From: Della Hart <[REDACTED]>
Sent: 24 March 2022
To: Amber Willard
Subject: Re: FP/273/21/HH

I am the officer on your application at 23 Felpham Way. FP/273/21/HH

Location Plan

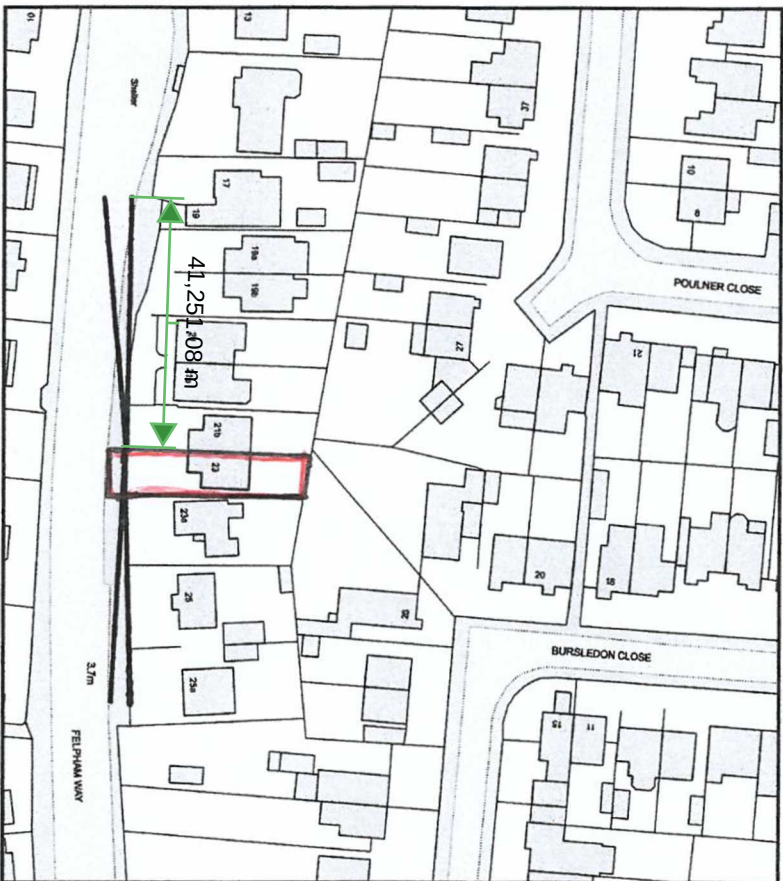
They request additional information regarding the width of the crossover.

- Please are you able to provide details demonstrating both the existing and proposed VCO widths.

From their comments, dropped kerbs wider than 6.4m per dwelling would not be granted a licence and therefore they require this info to determine whether the permission would be implementable.

The drive in total once the extension is completed would be 5.8 metres.

The current opening is 2.2metres and the extension is 3.6 metres.
